#### COMMUNITY DEVELOPMENT DEPARTMENT

June 28, 2022

Re: PA22-019 - Groundhog PRD - Technical Review 1

**GRADING AND COMPOSITE UTILITY PLAN**  
GROUNDHOG PLANNED RESIDENTIAL DEVELOPMENT

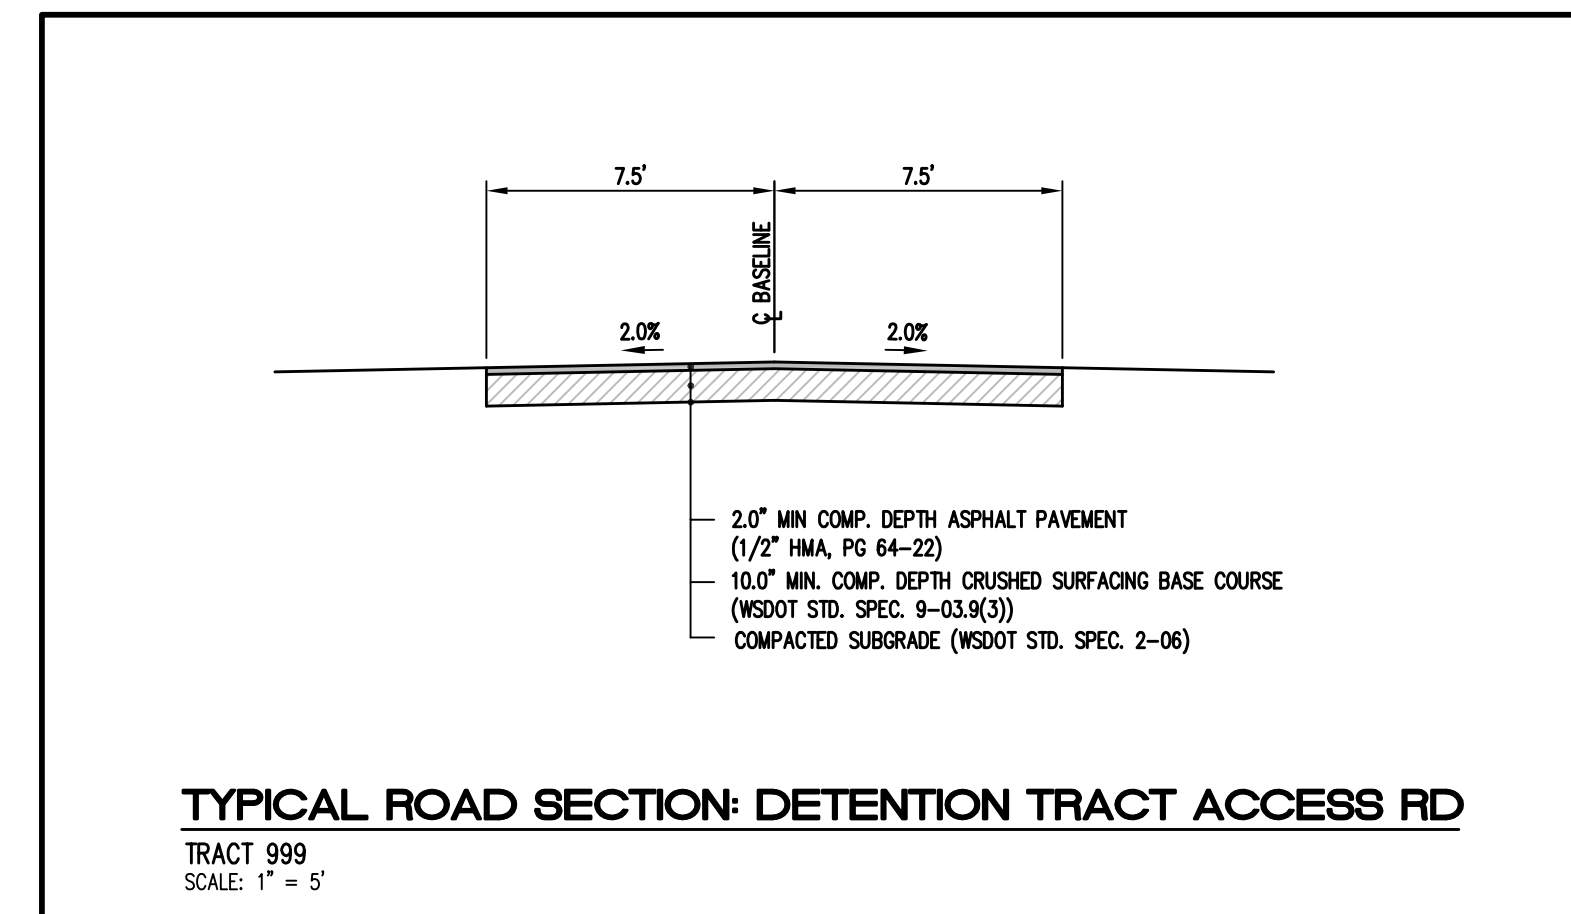
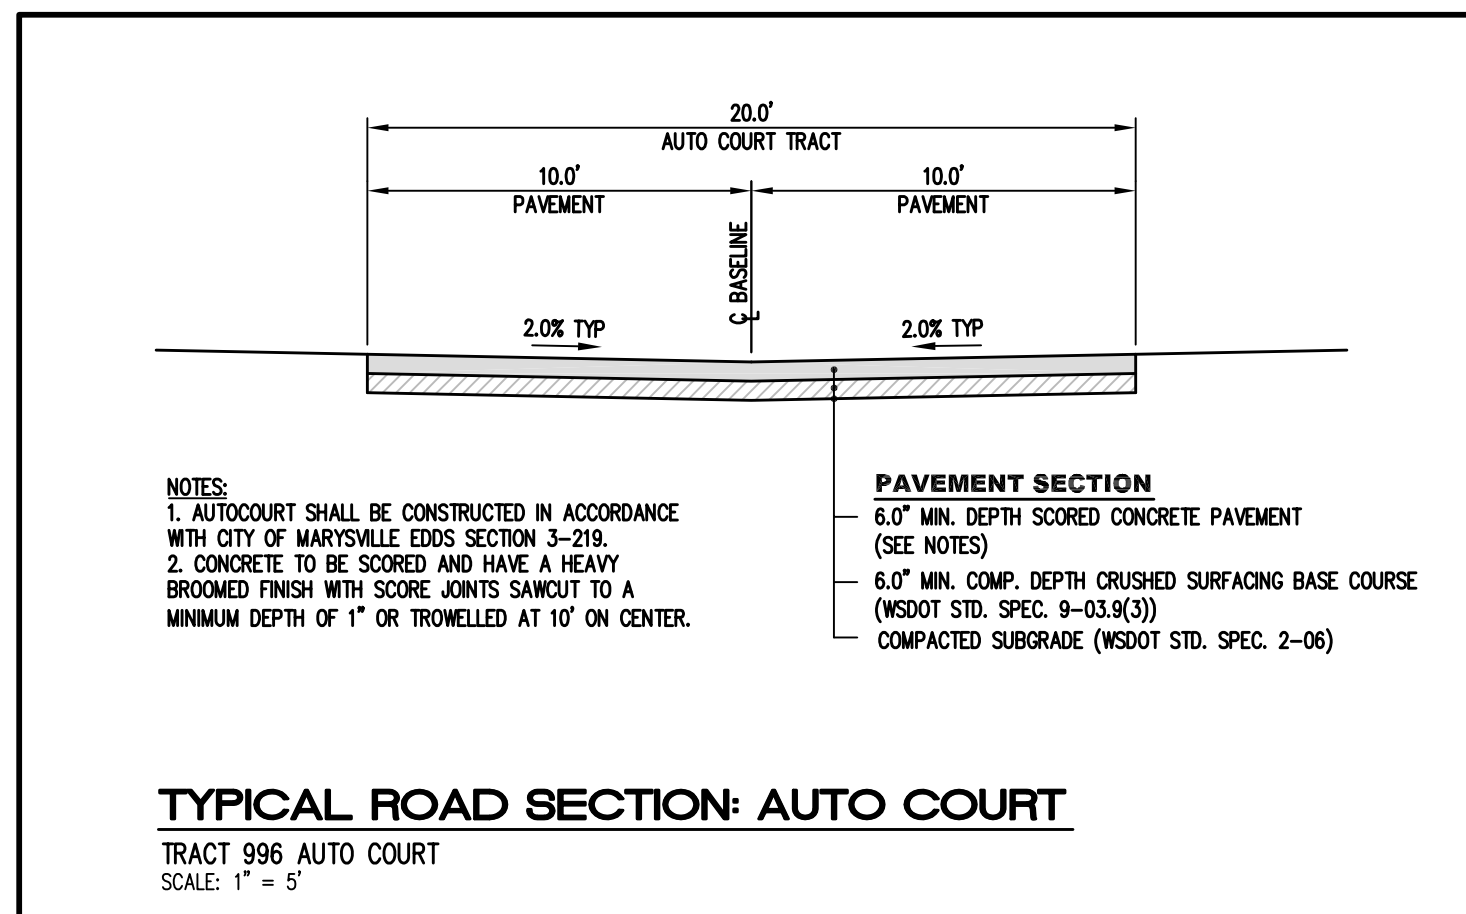
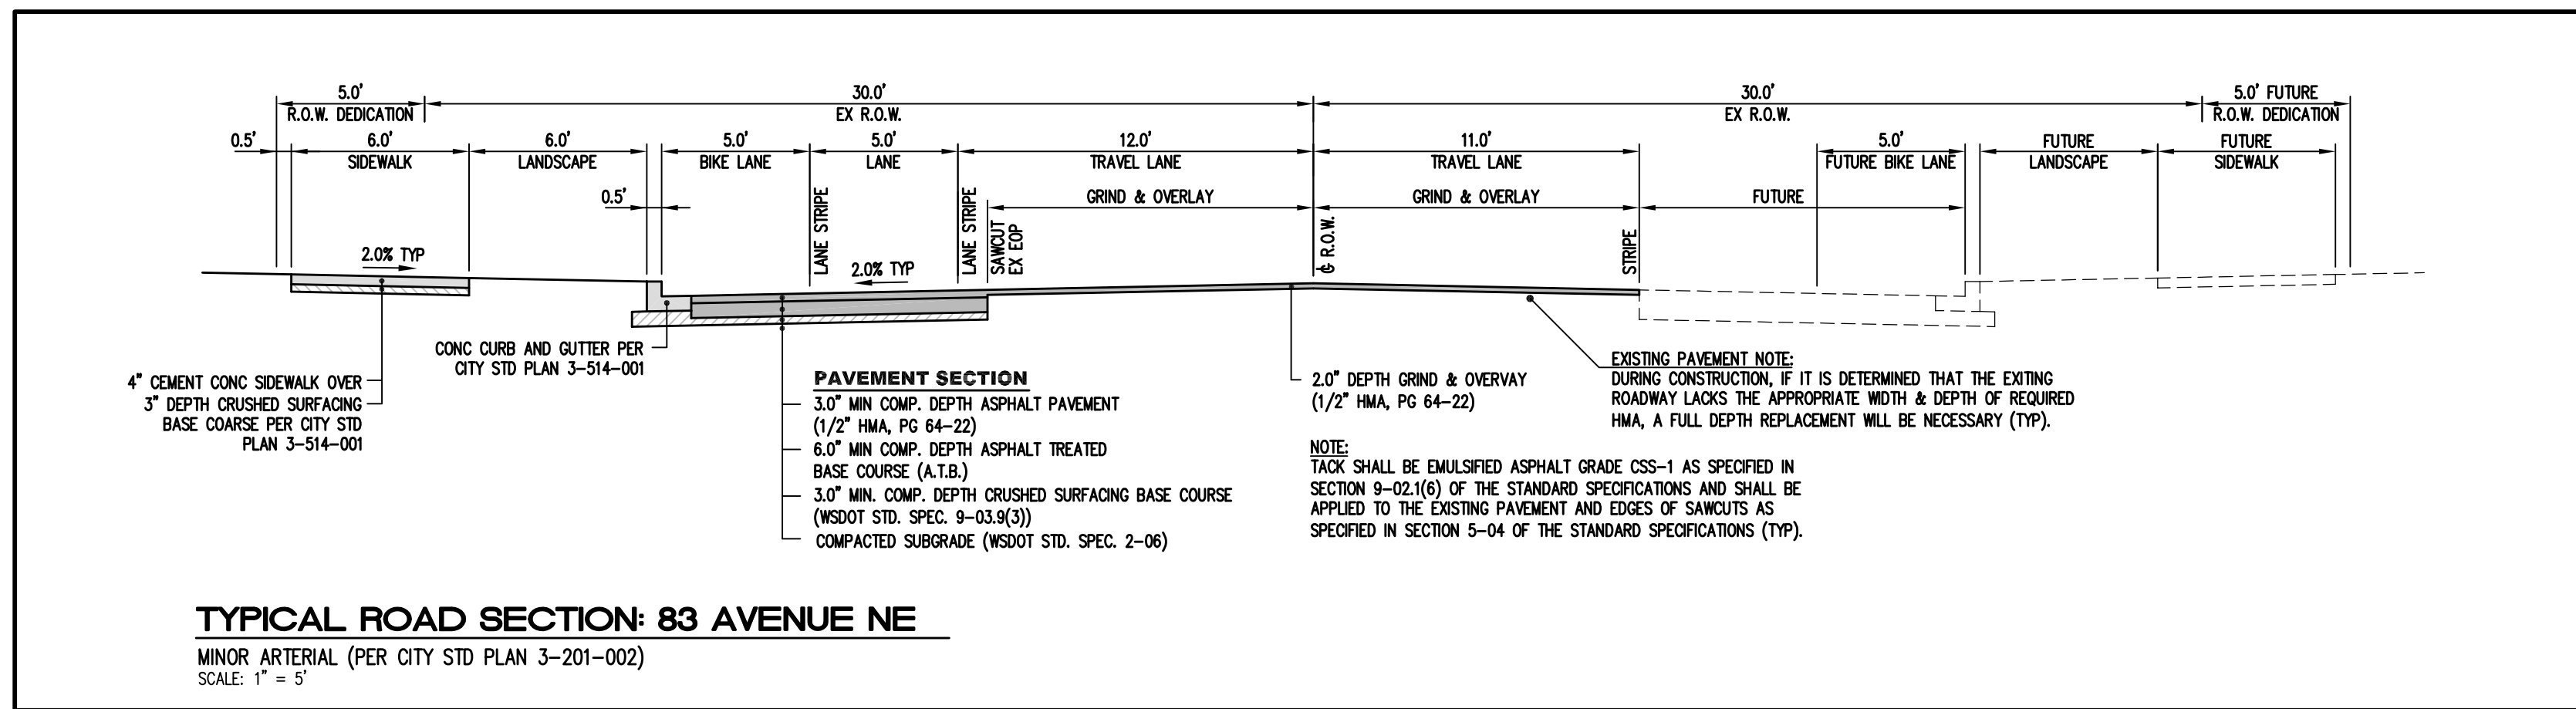
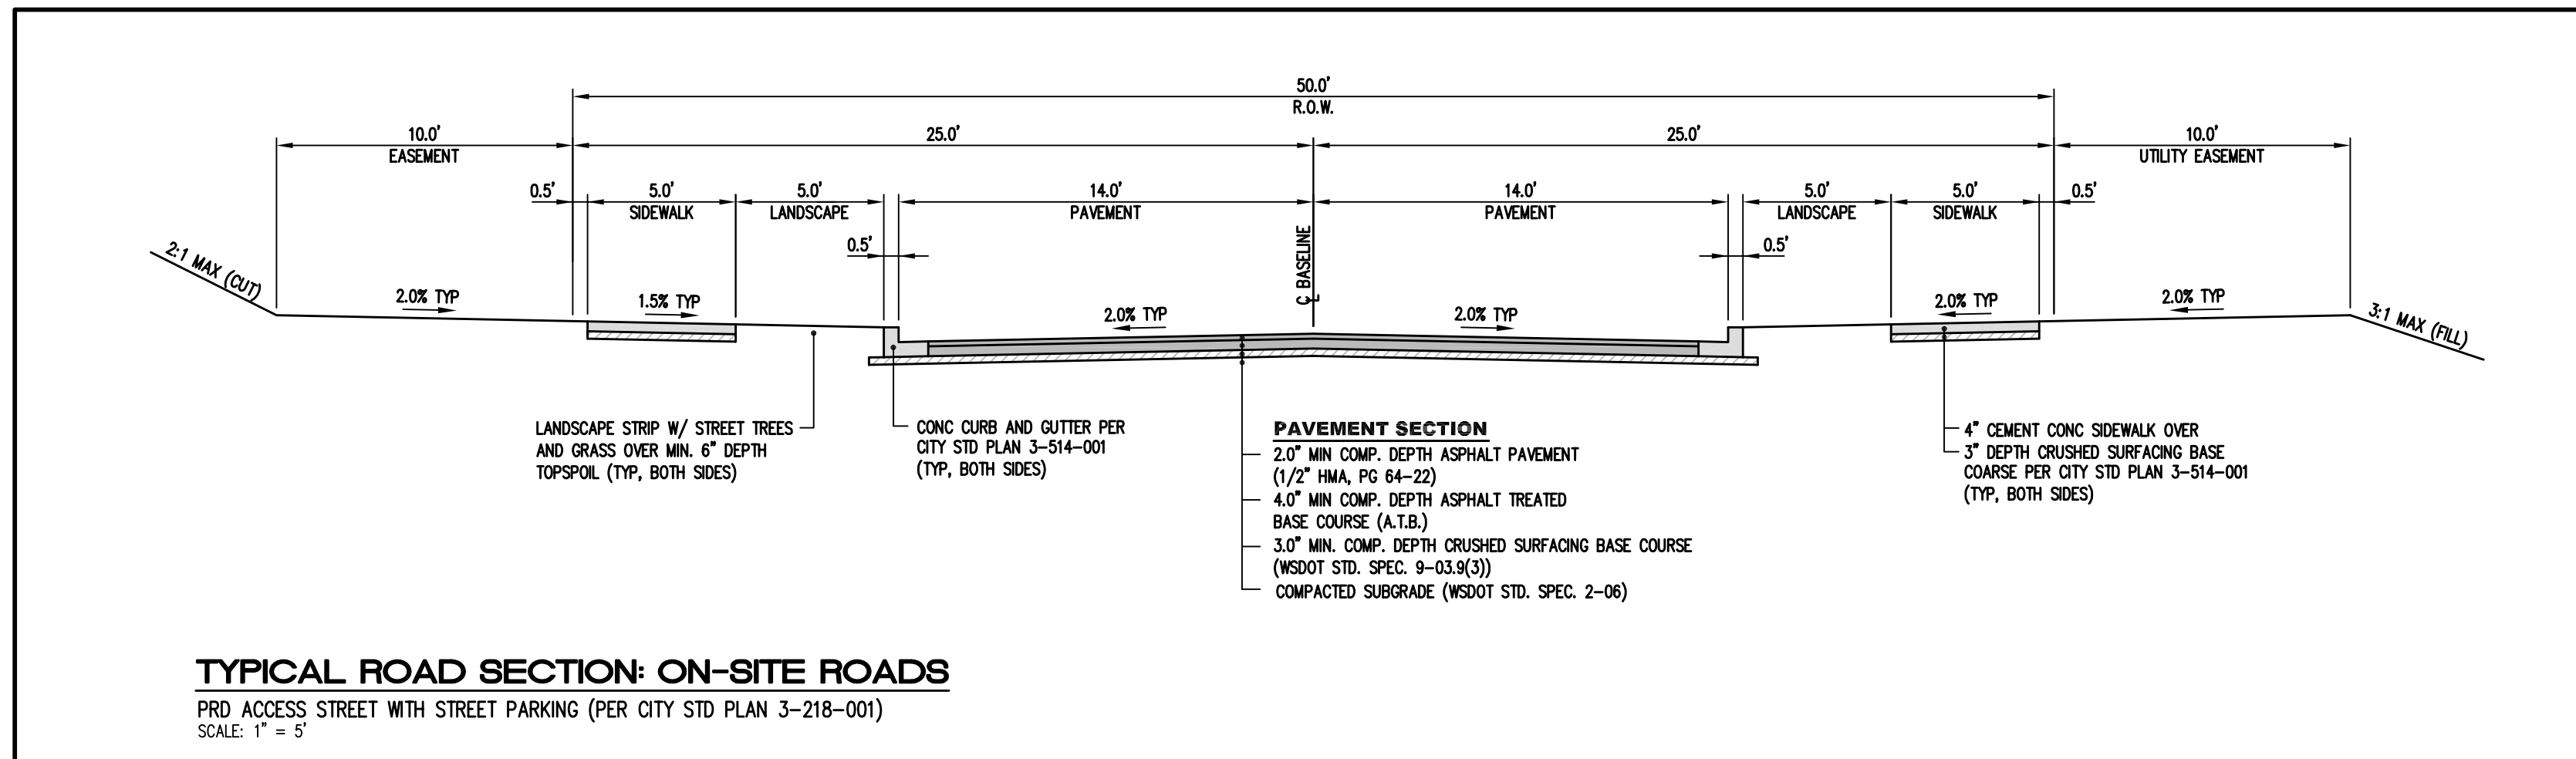
- Automatic sprinkler systems will be required on any lots beyond the proposed turn-around.
  Any lots requiring sprinklers shall be identified on the civil plans, and 1" meter-setters will
  need to be specified for those lots. Therefore, revise civil plans to identify any lots which
  will require fire sprinklers.
- 10. To qualify for RDI bonus units under 6 (b), qualifying passive recreation must be clearly demonstrated.
